CITY OF ALBUQUERQUE

March 30, 2017

RE: 8300 Calle Nortena NW
Grading Plan
Stamp Date: 2/7/17
Hydrology File: C11D003

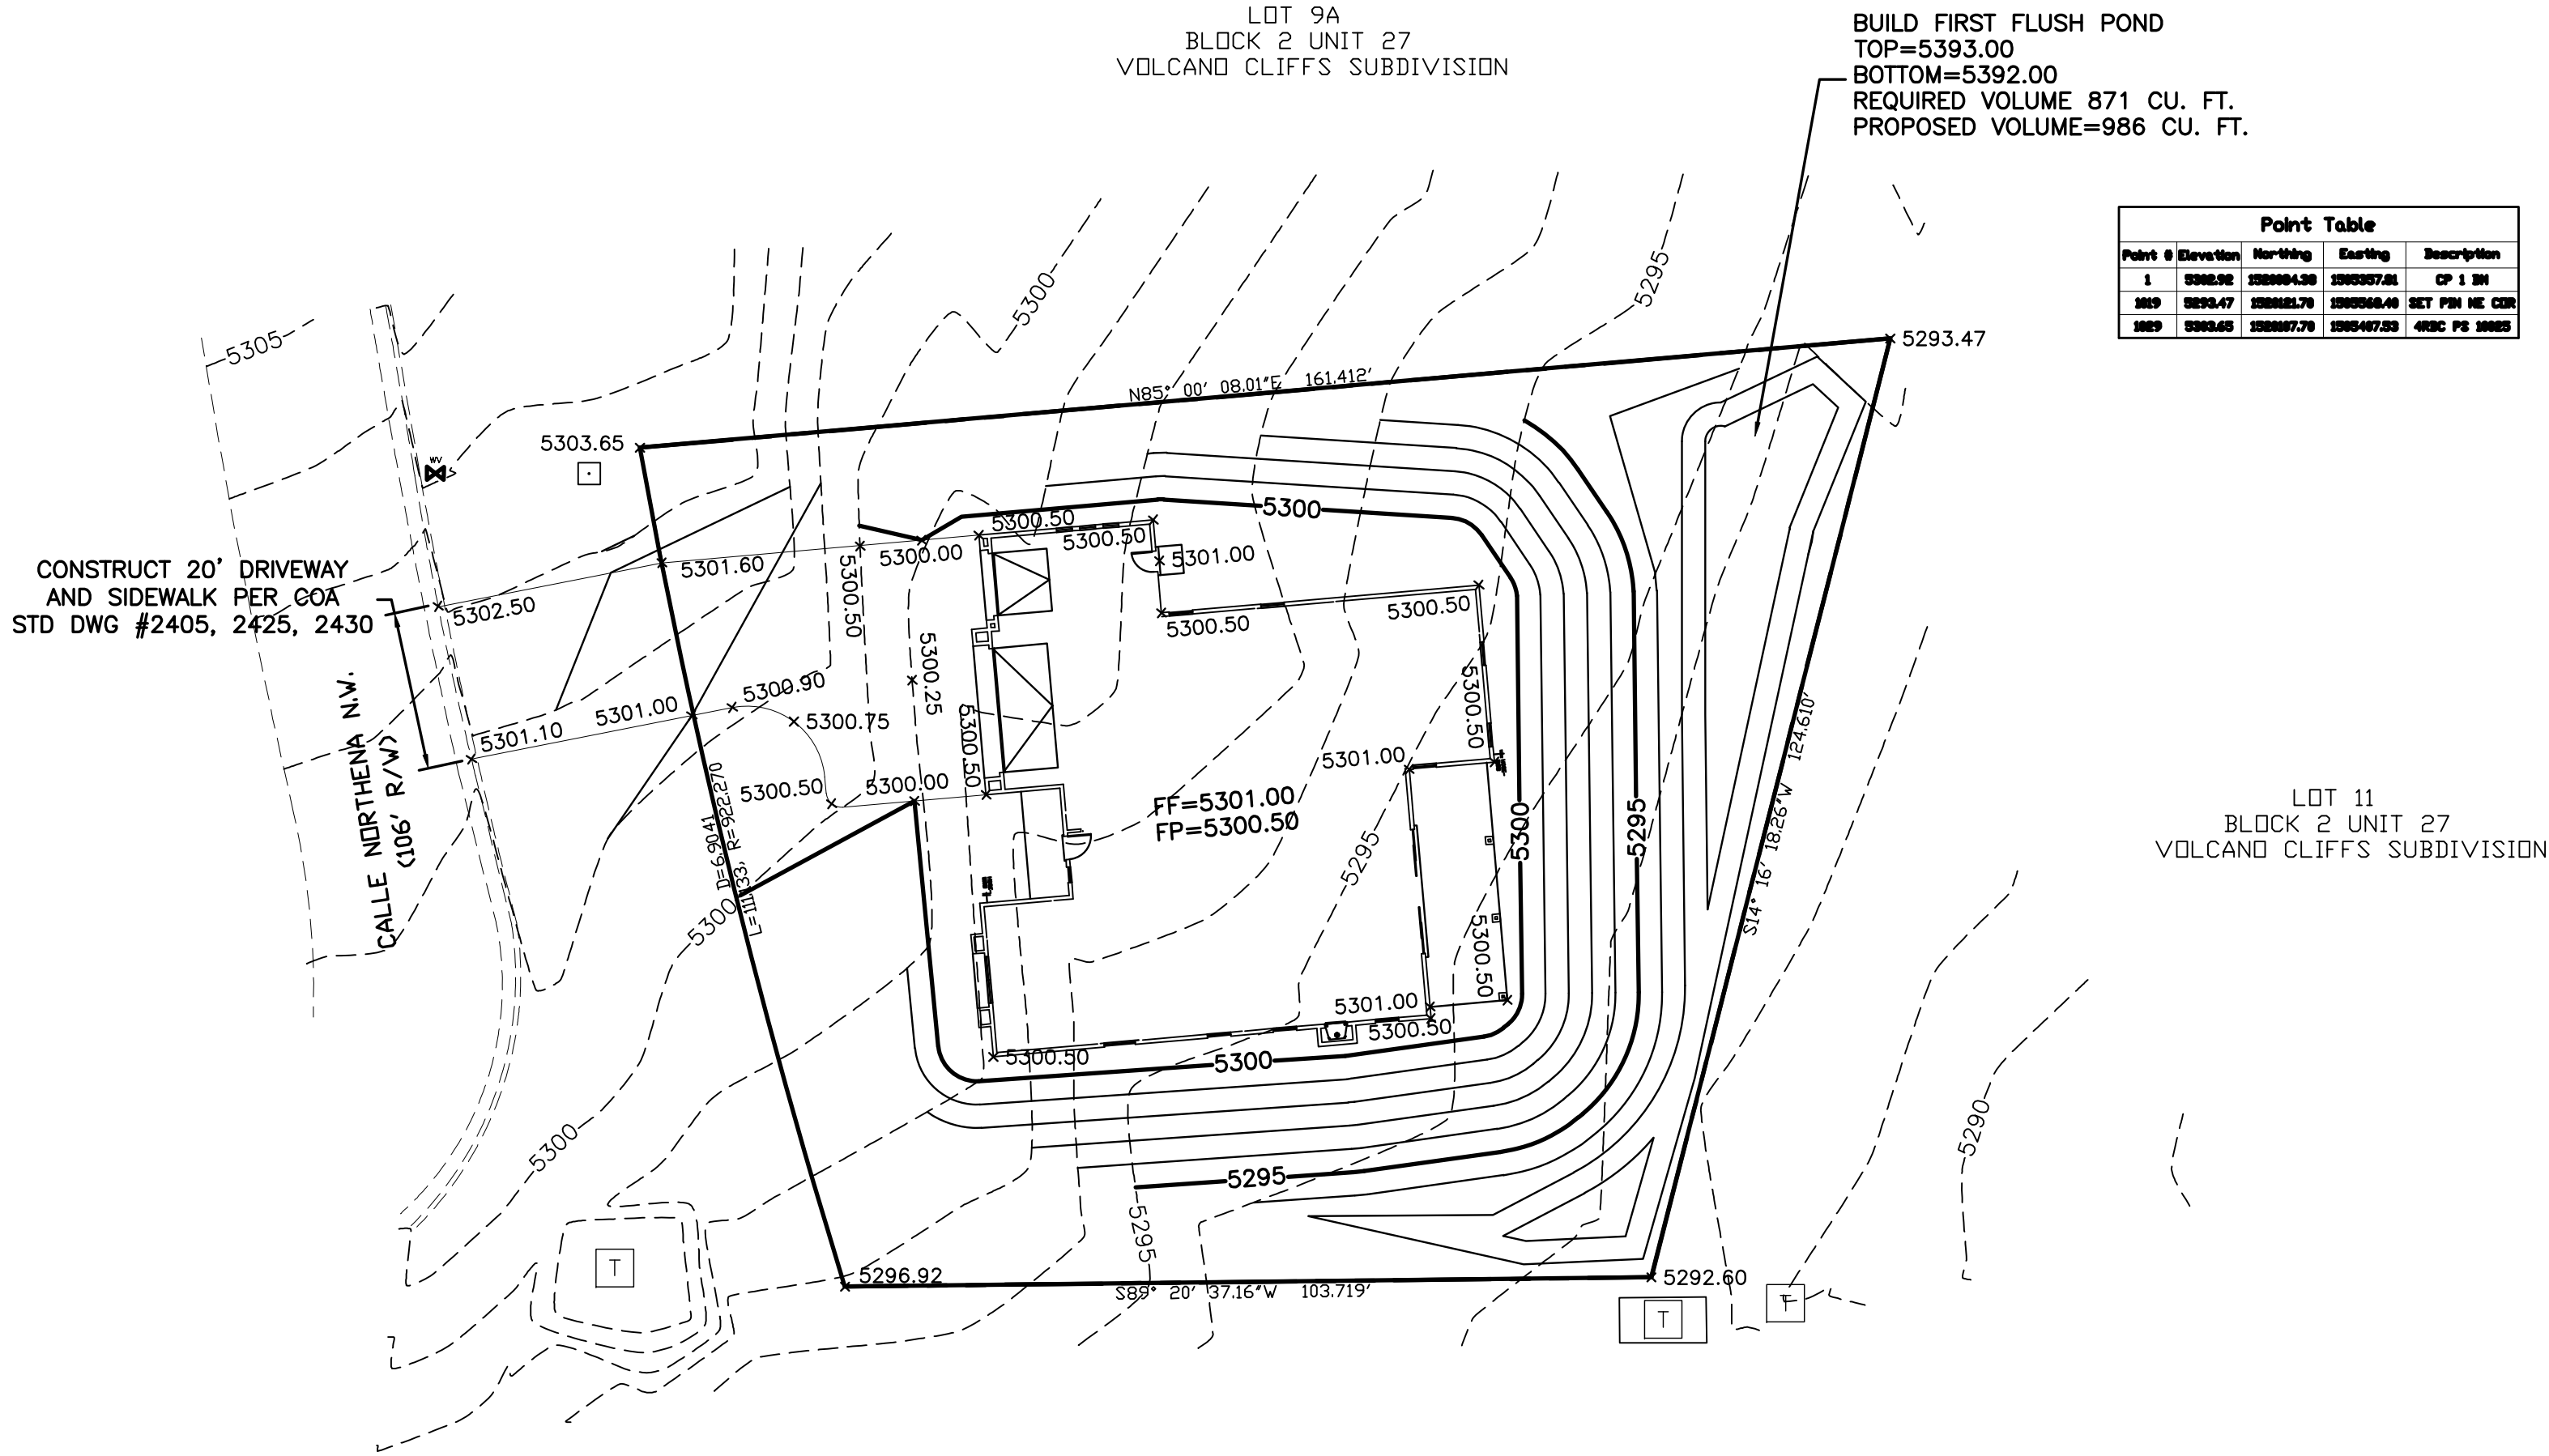
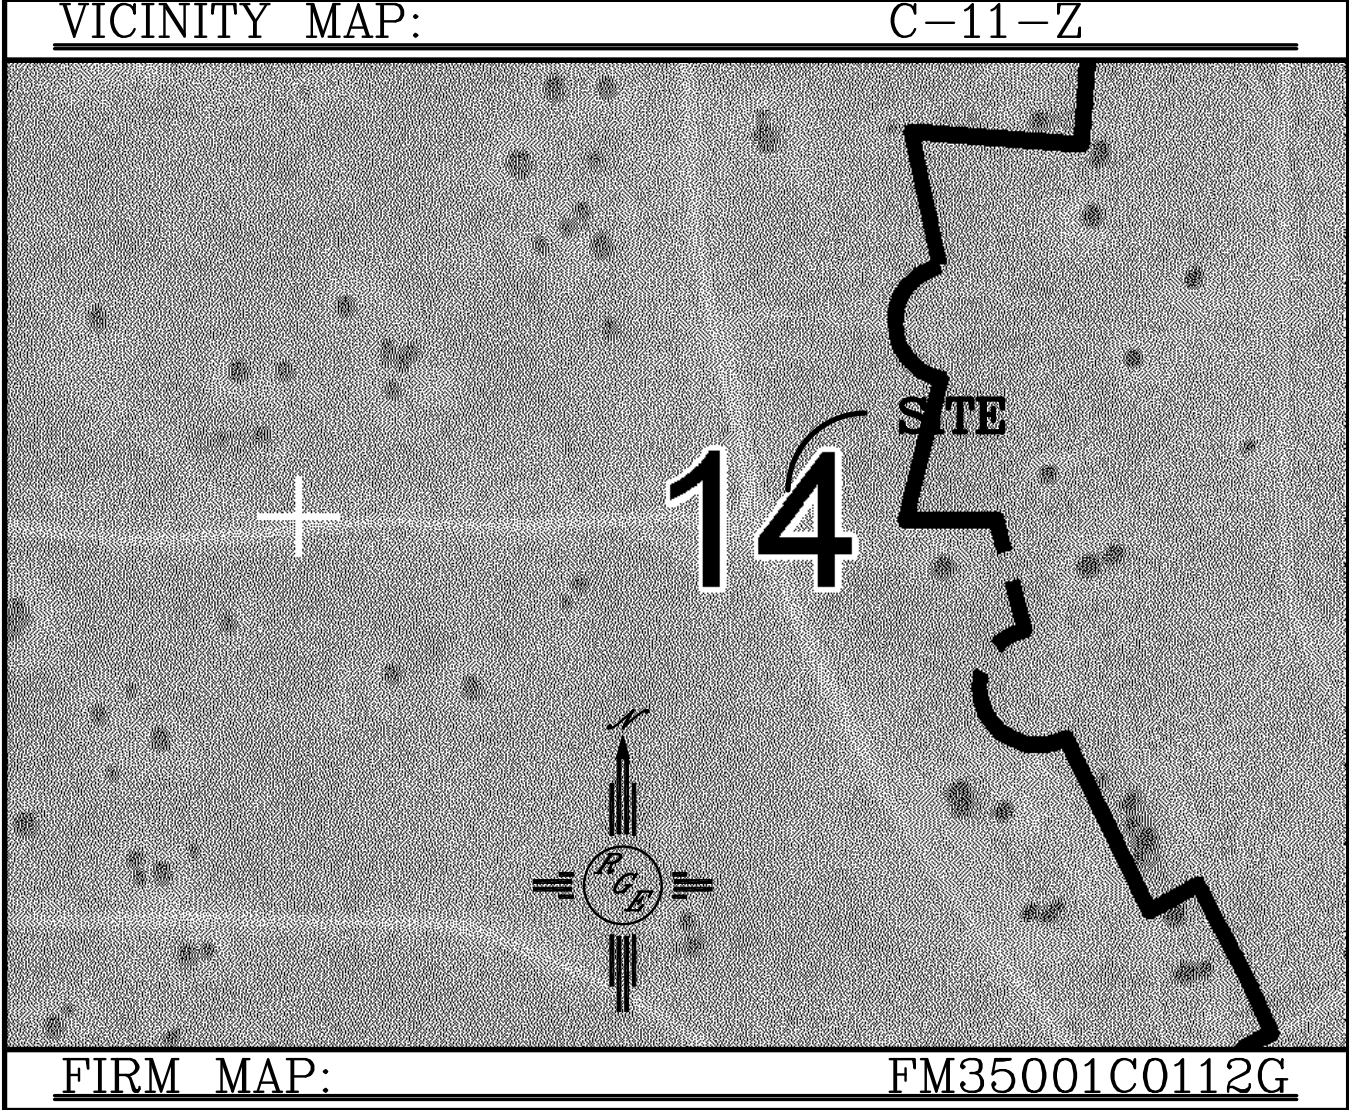
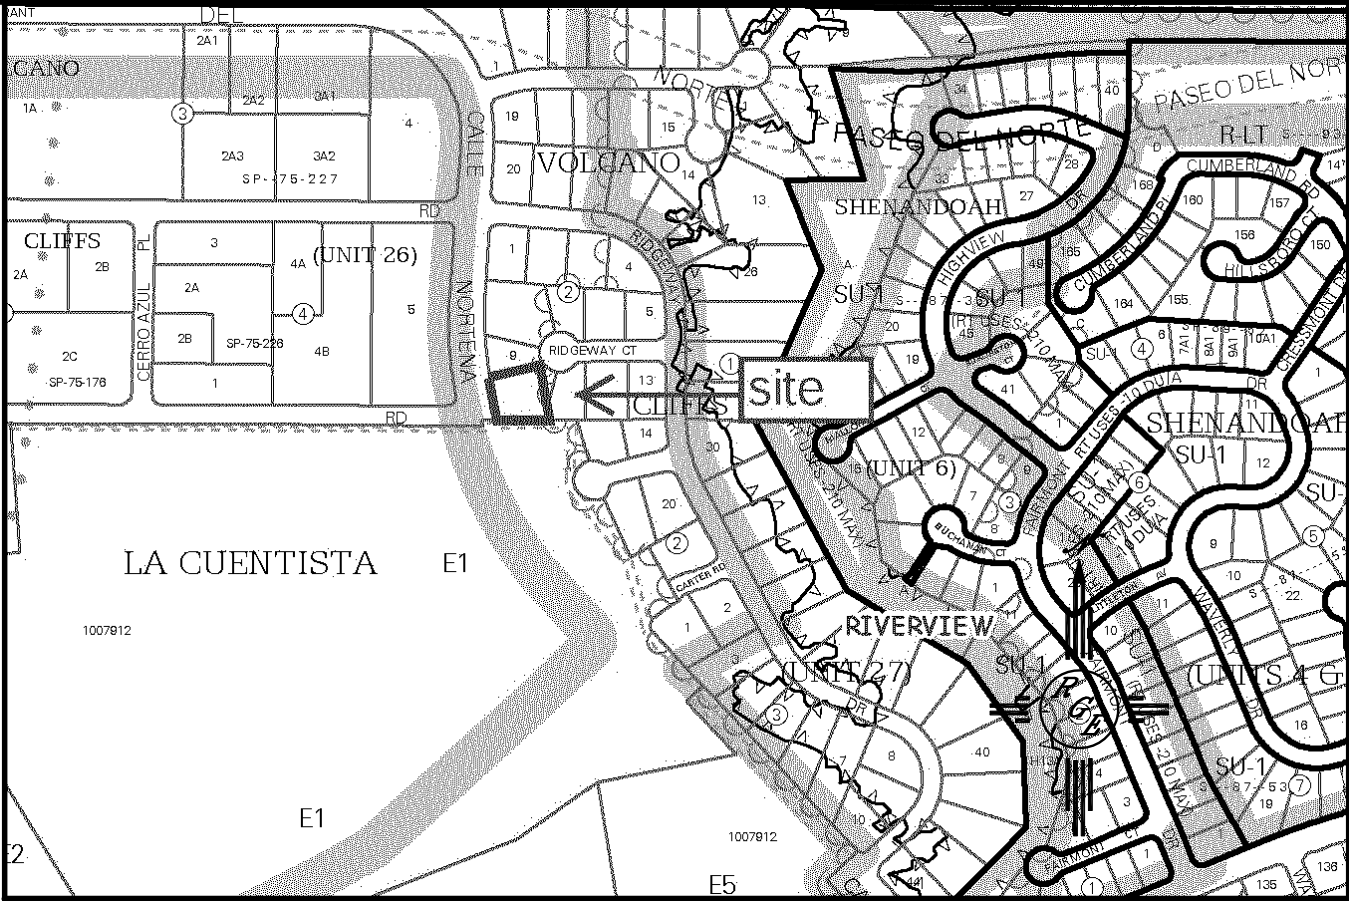
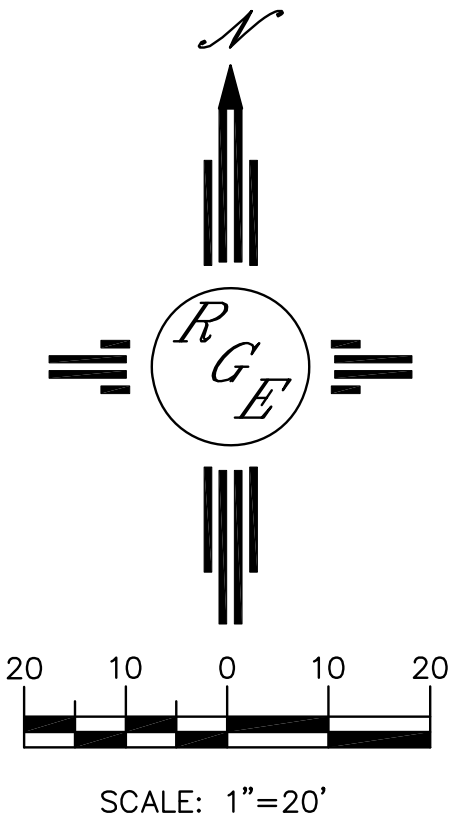
1. It appears that you calculated required volume for capturing the first ½ inch (detention) is low. It should be 0.02 ac-ft or 871 CF.
2. The proposed grading appears to actually separate the site into two separate drainage basins. The north half drains to the proposed pond. The south half drains to the southeast corner of the site. The south half of the site's drainage is not captured by a pond and just directly flows off site. You need to create a pond to capture the runoff.
